**Consultation Response from KC,
Highways Development Management**

2022/92081 Land at, Huddersfield Road/Leeds Road, Birstall, Batley, WF17 9AA

Demolition of existing buildings and erection of retail food store with associated parking and landscaping

Title Proposed Site Plan		Client Wharfedale Ltd.	
MWA Project Ref 6228	Scale 1:200	Original Paper Size @A1	Paper Orientation Landscape
Files Identifier Project	Originator	Volume	Level
WLLR - MWA - XX - XX - DR - A - 1001			
Revision	Role	Number	Revision
P6

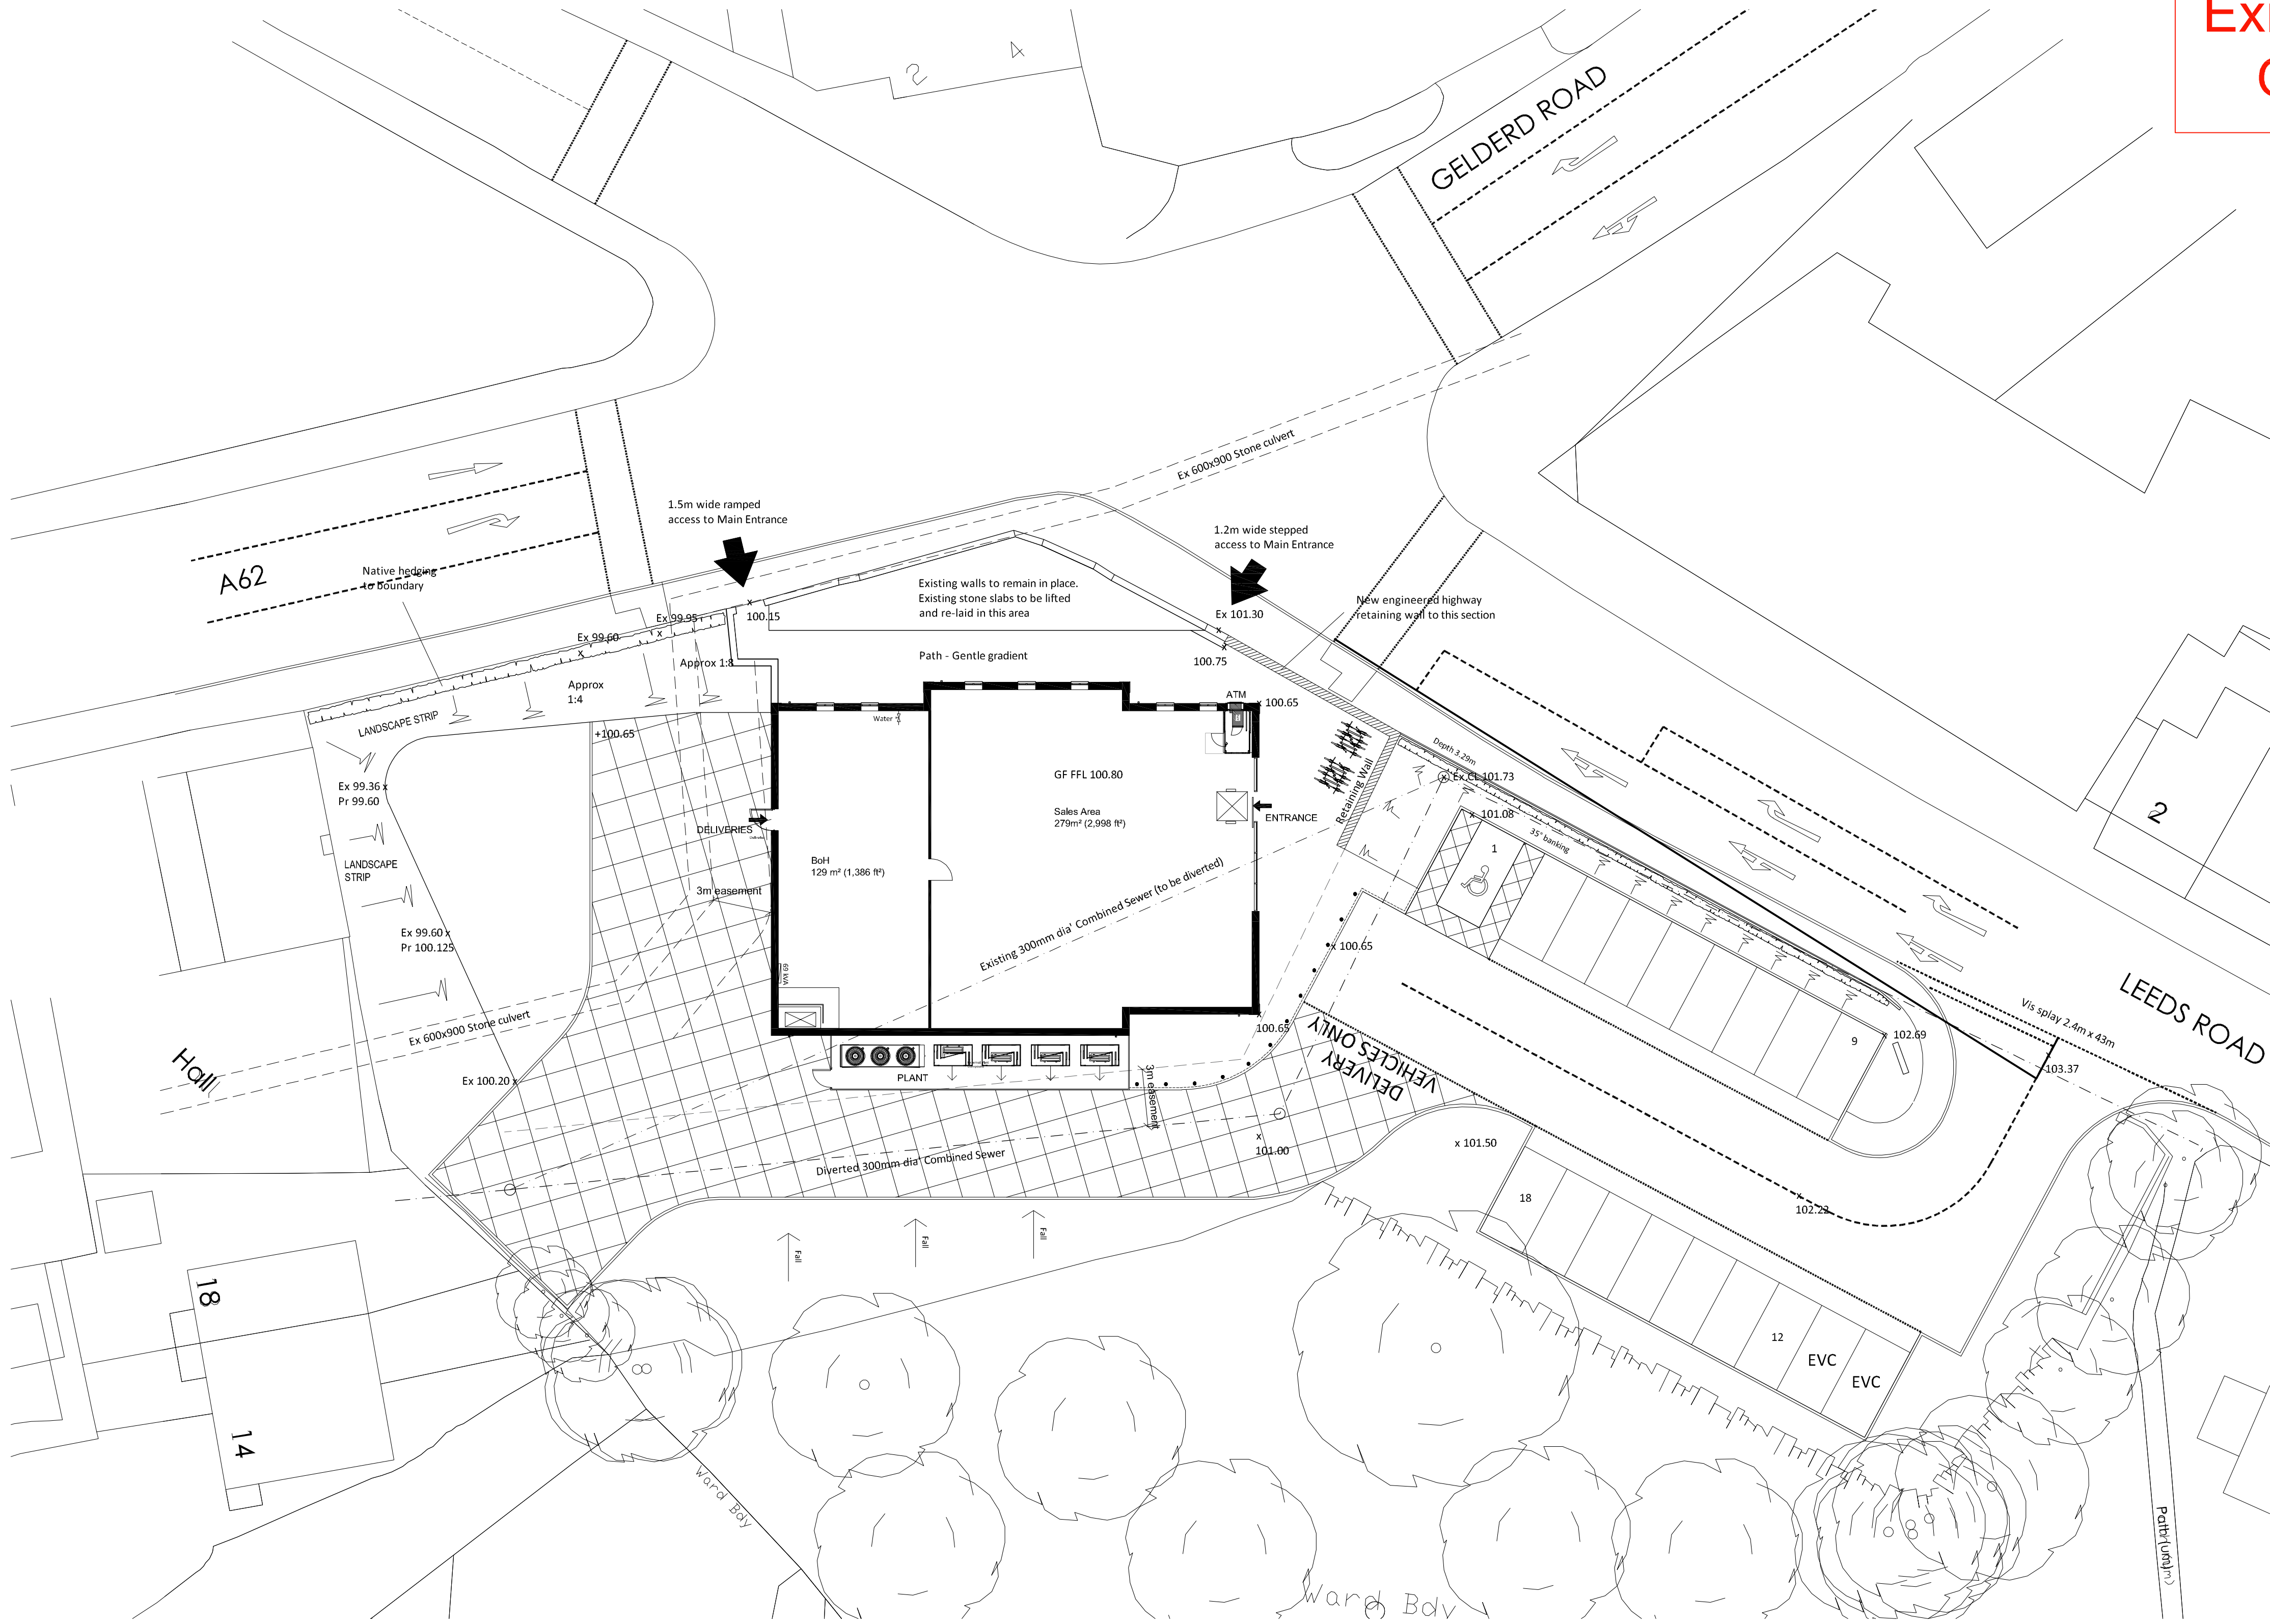
It is proposed to improve the existing access point off Leeds Road for the development. This access is shown to be widened to around 9.7m to allow sufficient access for all traffic including service and delivery vehicles to the site. The result of the widening has provided a slight improvement in visibility at the access of 2.4m x 21m (to wheel track) and 2.4m x 43m to the west.

1, A stationary bus at the stop immediately adjacent to the access will severely obstruct visibility to the right for a driver exiting the premises. Pedestrians stood at the bus stop will also hinder visibility to the right when exiting the premises.

2, Drivers exiting the premises and turning right through queuing traffic will struggle to see vehicles approaching from the A62. Drivers turning right into the site through a queue may struggle to see pedestrians.

3, Right turn in/left turn out HGV turning movements from Leeds Road into the site may be difficult given the acute angle and the potential conflict with traffic queuing back from the signals.

5, It is uncertain whether an adequate visibility splay to the right can be achieved when exiting the premises.

- 1, Only a 12-metre heavy good vehicle is tracked which is un-acceptable. A 16.5 metre articulated HGV should be tracked. The proposed servicing arrangement are therefore not shown to be acceptable.
- 2, There is no pedestrian access shown into the site from the east and the eastern kerb line of the access junction onto Leeds Road runs through the location of the existing bus stop. There is no existing footway to the east of the access and therefore no obvious location to re-site the bus stop other than close to the A62/ A643 junction which would not be acceptable.
- 3, Visibility to the east or left of the proposed access when exiting is sub-standard.
- 4, The TRICs Assessments of the existing uses may not be representative and the net increase in two-way movements in the peak hours may be higher than stated in the TS.
